Hornsby Ku-ring-gai Hospital State Significant Development Response to Submissions

Stage 1 Redevelopment

Submitted to Department of Planning & Infrastructure
On Behalf of NSW Health Infrastructure

April 2013 ■ 12290

SOUTH ELEVATION. (BURDETT ST).

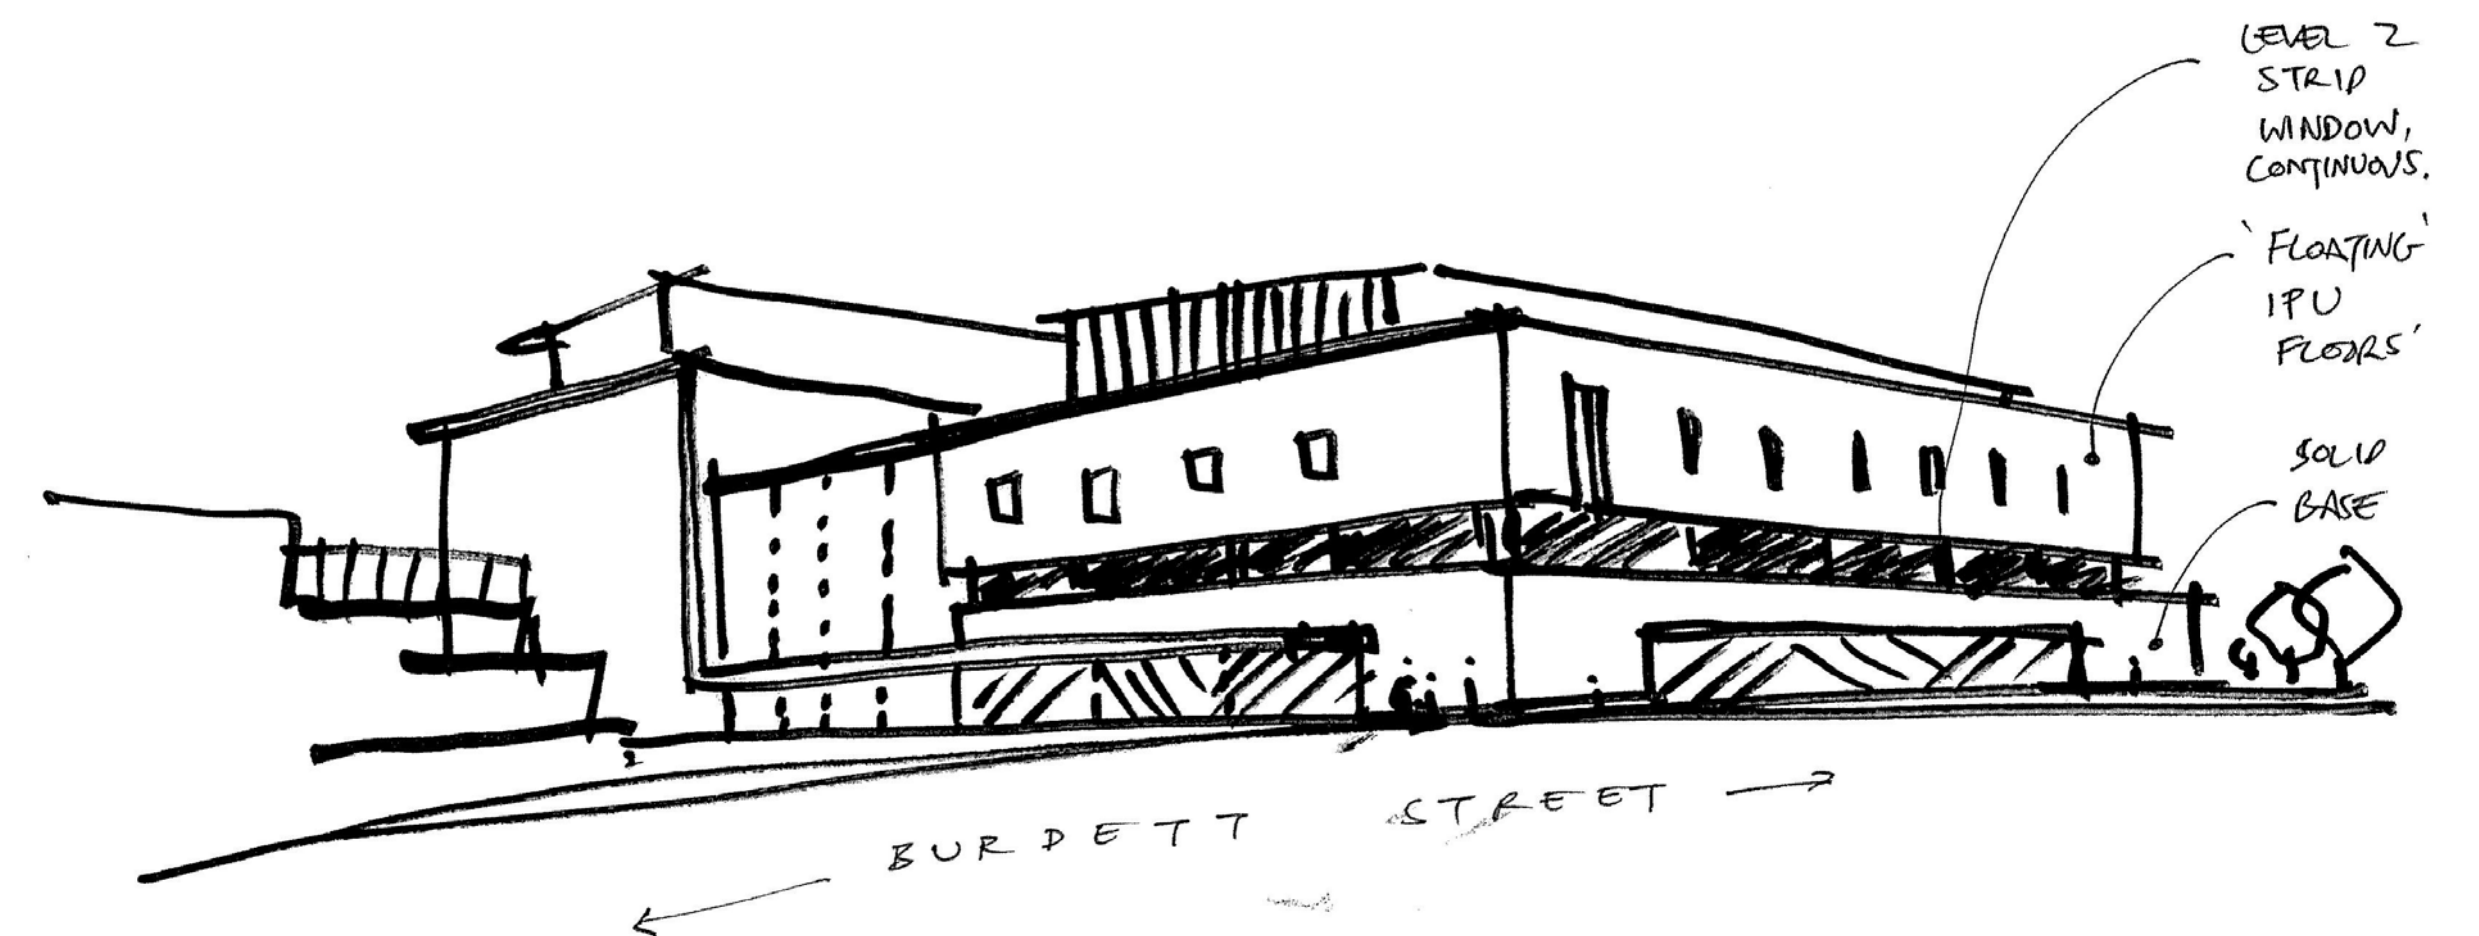
However, the setback of the proposed building is only 2.7m from the southern boundary (Burdett Street), and the height of the building in this location is between 13 to 14 m above existing ground level, which is significantly higher than existing residential development opposite the site. Whilst the department acknowledges the design evolution and measures included to minimise visual impacts of the building (outlined above), the current southern setback of 2.7 m does not facilitate an adequate deep soil zone to allow vegetation of an appropriate size to exist and provide appropriate screening of a building of this scale. The department therefore requests that a greater setback be provided, along with an increased deep soil zone in collaboration with additional plantings of mature vegetation in this location. Further details of the type and arrangement of vegetation to be used in this location to provide appropriate screening of the Stage 1 building is to be detailed in a separate landscape plan.

Notwithstanding the above, modifications have been made within the setback between the building and Burdett Street to provide capacity for further mature and buffering landscaping. This has been accommodated by narrowing the concrete maintenance path to the building edge. A landscape plan and report prepared by Arcadia has been provided at **Appendix D**. The plan shows the retention of the trees which currently grow in the Council verge with the addition of *Tristanopsis Laurina* (Water Gum) within the setback to supplement the existing screening. The trees will grow to a height of approximately 6 metres (or 2 storeys) and will be planted at regular intervals of 5 metre spacing. This additional planting will offer a year-round buffer to the building's built form as well as functioning as visual relief to the building façade along Burdett Street.

Further to the above, Woodhead has also provided a section sketch that illustrates a person's sightline to the building from Burdett Street. At a height of 1.5 metres, a typical person standing on the opposite side of Burdett Street looking at the Stage 1 Development would not have a sense of the proposed building being dominating or 'overlooming' given its massing, setback and width of the Burdett Street road reservation. The building is appropriately scaled for its context (see **Figure 3** over).
